**Transport – The A449**

**Issue 1:** The 1.8km section of the A449 immediately to the north of J2-M54 is missing from the Applicant's Appendix 11.5 data/analysis.

Plot Date: 27 February 2020 12:46:11
File Name: \\uk06s2p\psw001\1\ie\ENVIRONMENT\Practice Areas\GIS\Projects\M54\M6 Link\Workspace\Stage 3 Figures\Landscape and Environment- Noise and Vibration\HE514465-ACM\EGN-M54_SW_PR_Z-DR-LN-0004 - Figure 11.3 - Long Term Change.mxd

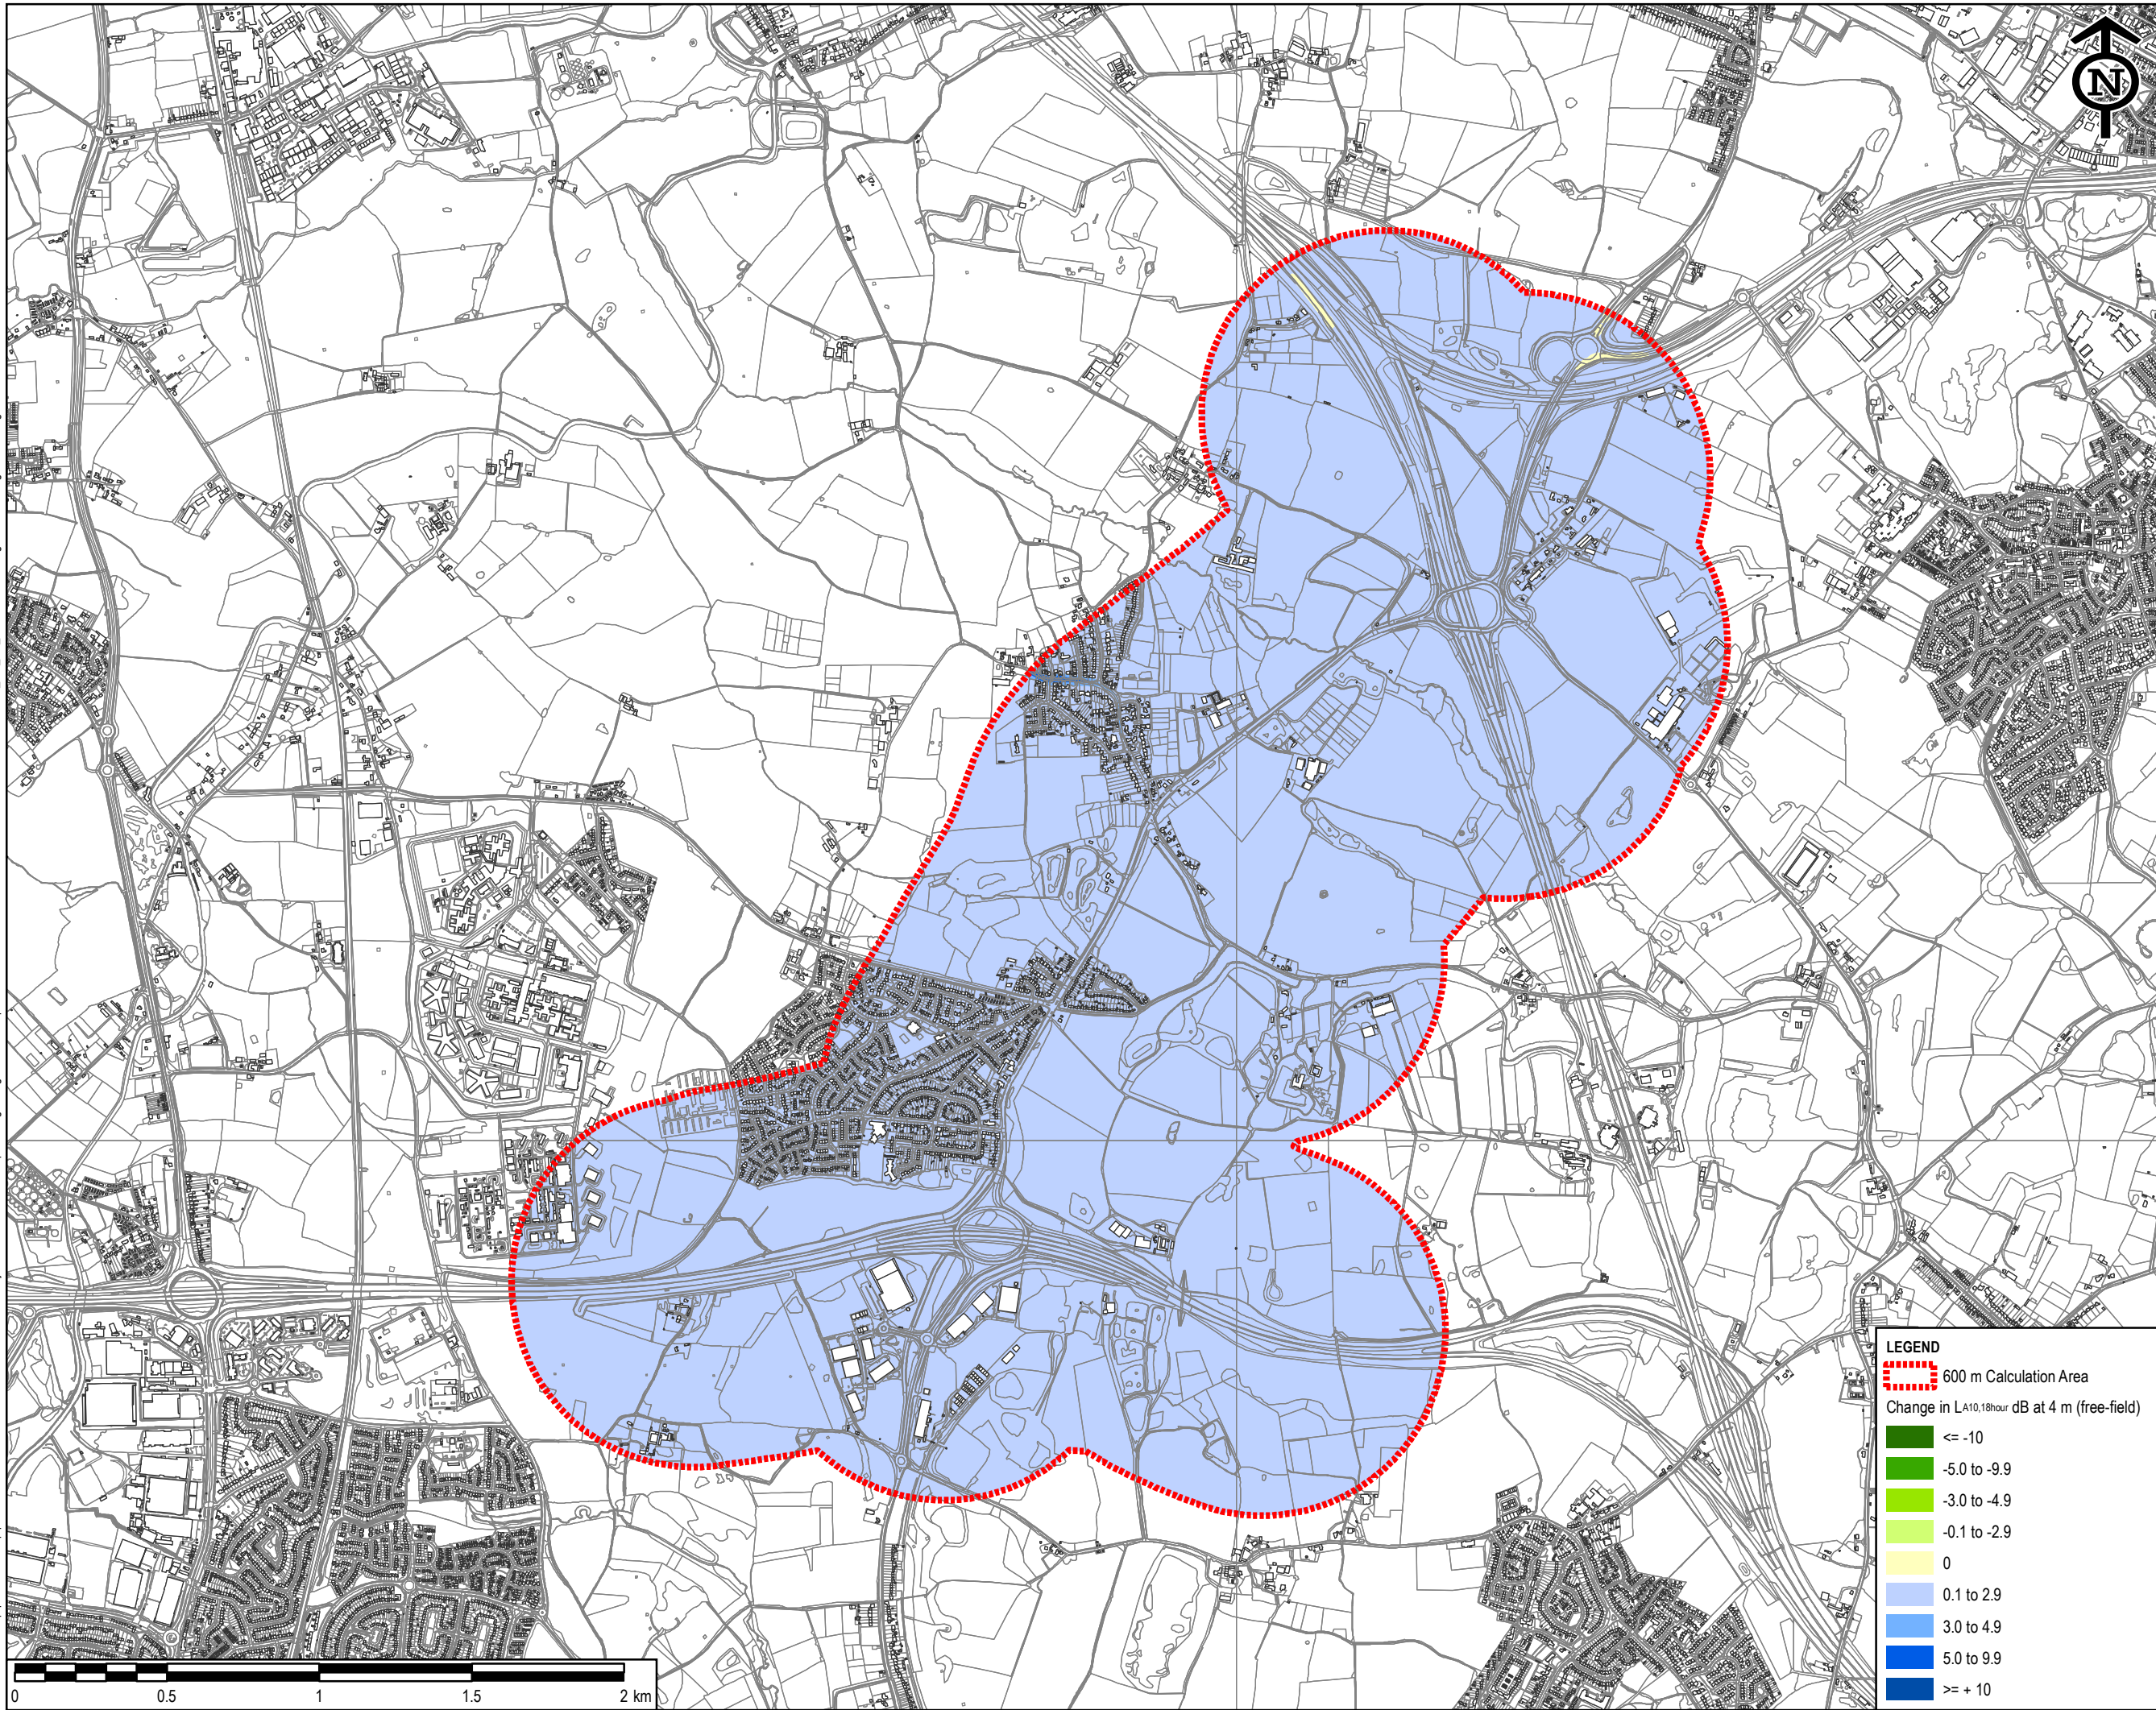
The second point to note is that the Applicant’s examination submission contains multiple examples whereby the 600m buffer around new carriageways has been ignored where it has been beneficial to do so from the Applicant’s point of view. Figures 11.1, 11.2 and 11.3 very clearly illustrate this point.<sup>345</sup>

Drawing Number HE514465	Originator -GHX	Volume -LLO	Rev P07
Location Z1_SW_PR_Z	Type -DR-LR-1002	Role -DR-LR-1002	Number

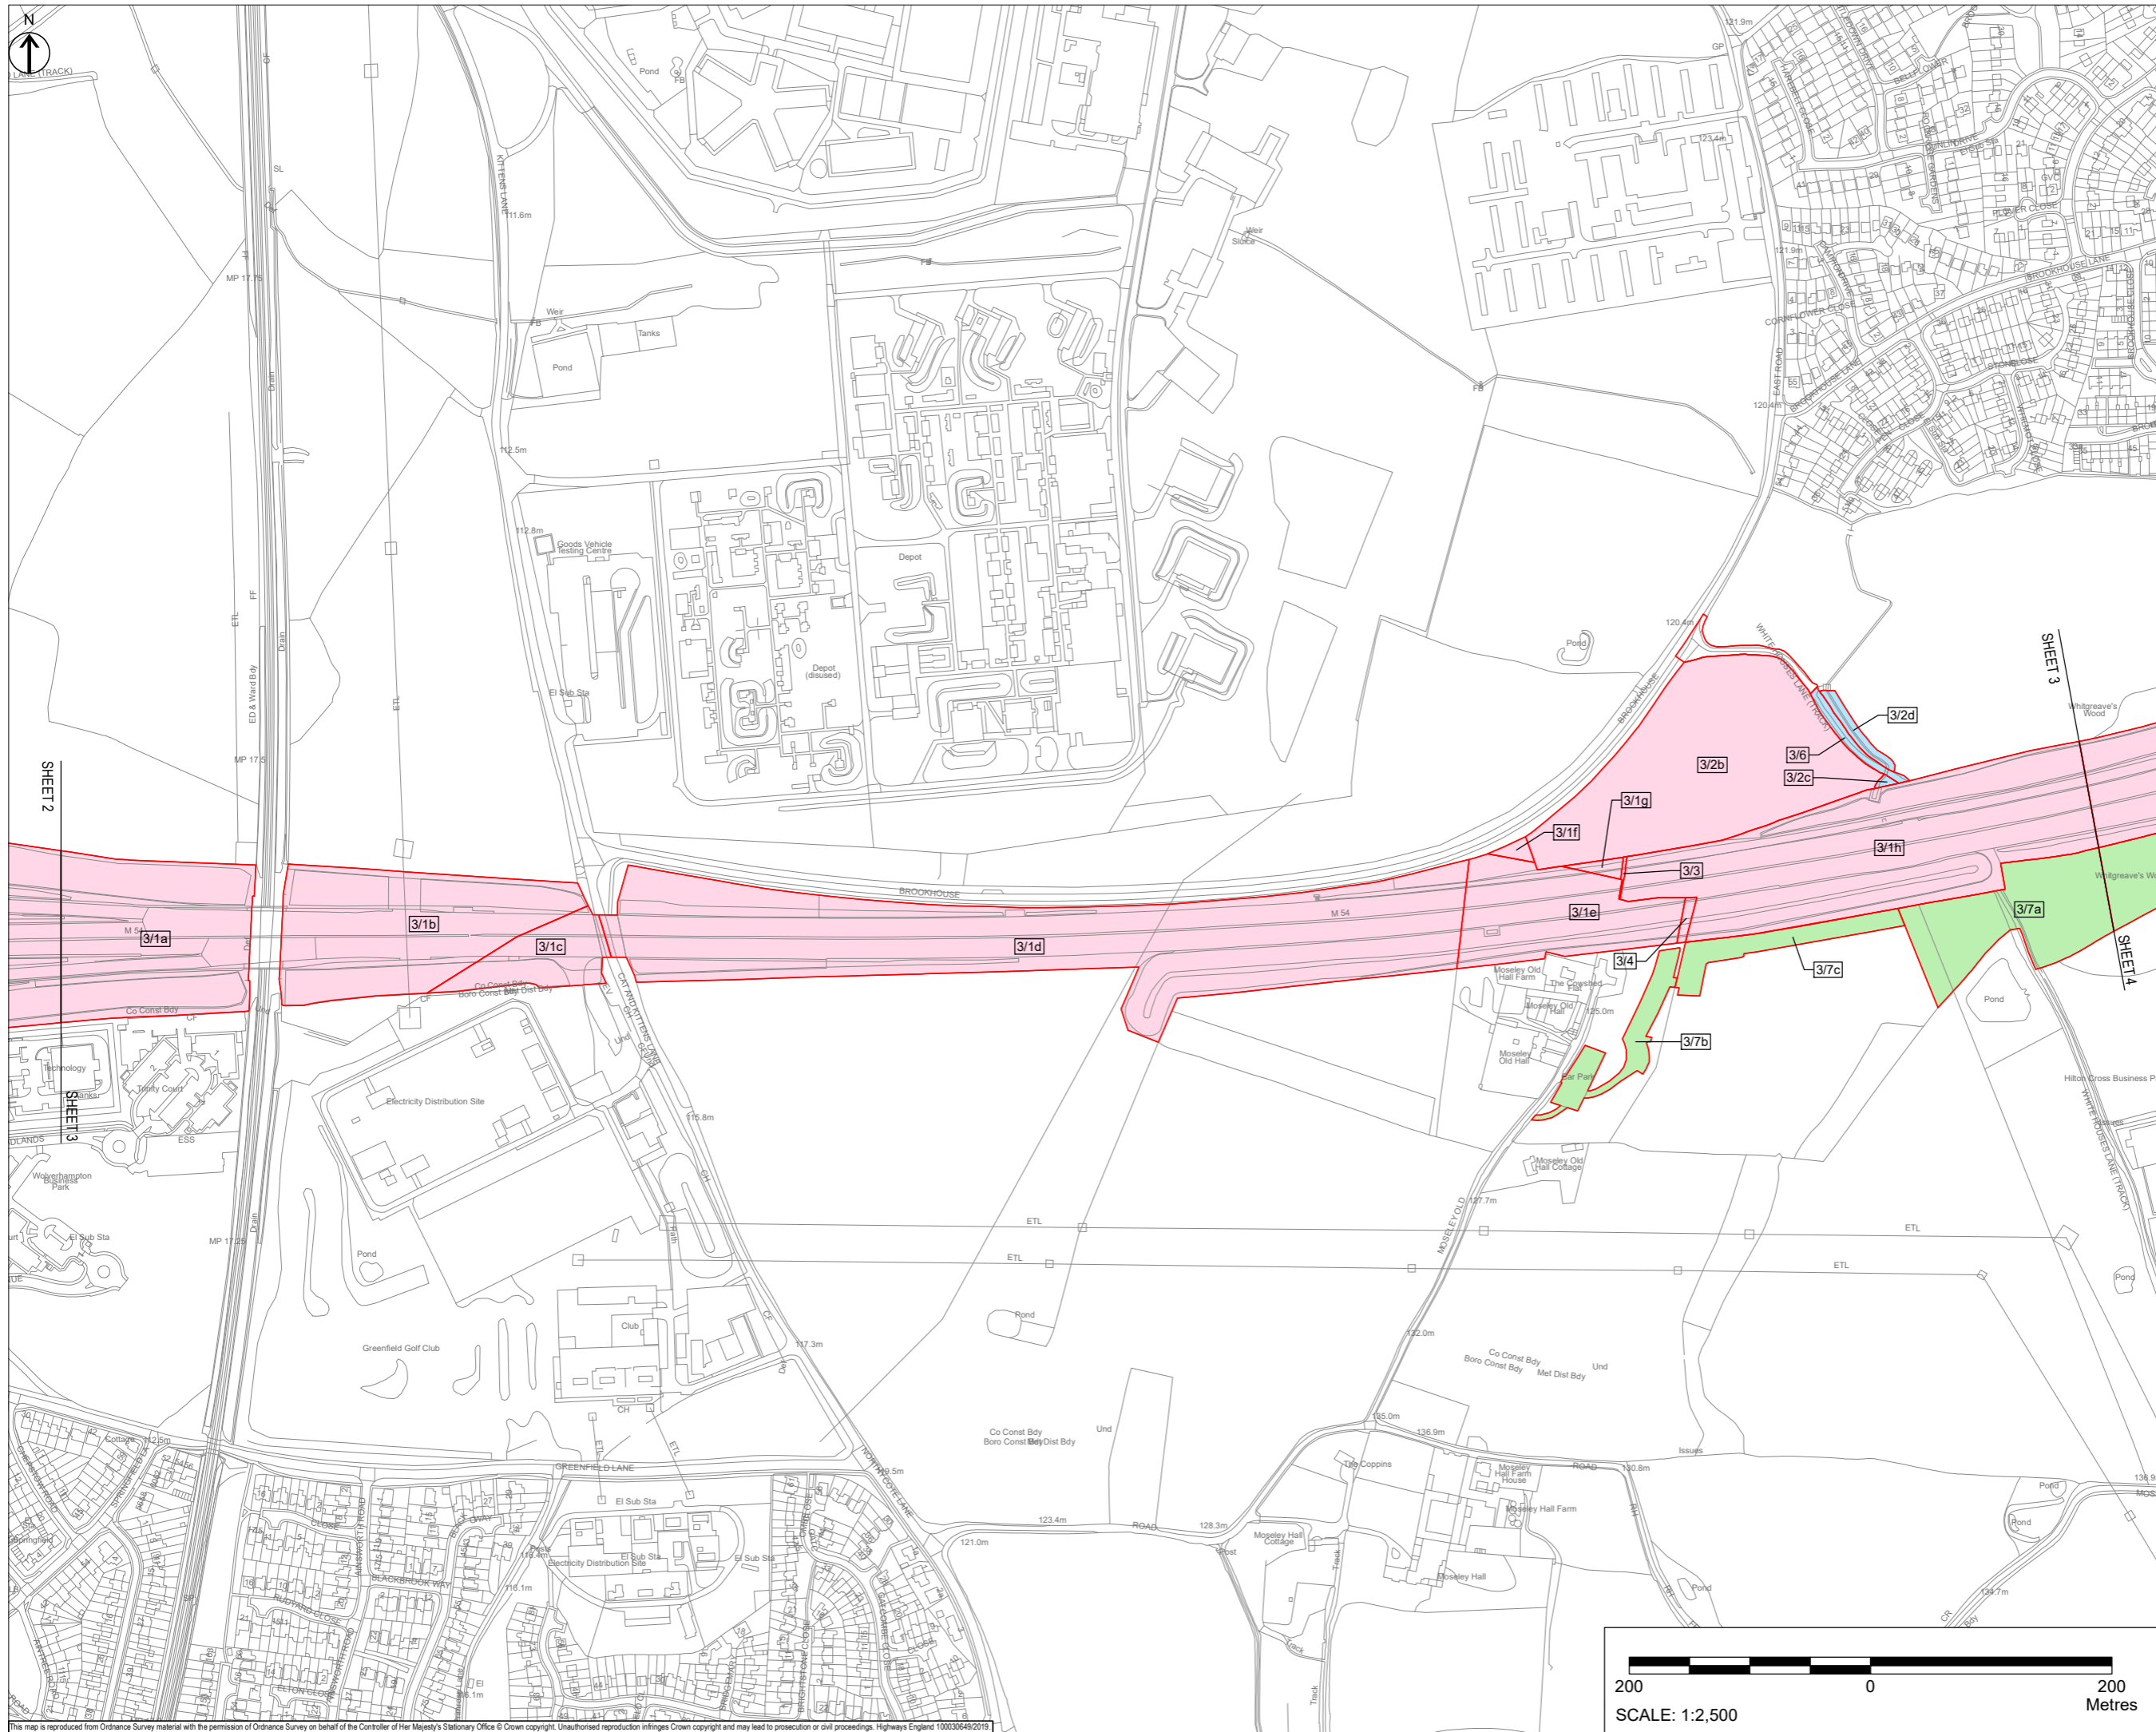
**DW’s Deadline 9 Response** – 70 dwellings reside within very close proximity to the 1.8km stretch of the A449 to the immediate north of J2-M54 with at least 50 of these dwellings also residing within 600m of the Order Limits red line<sup>2</sup>.
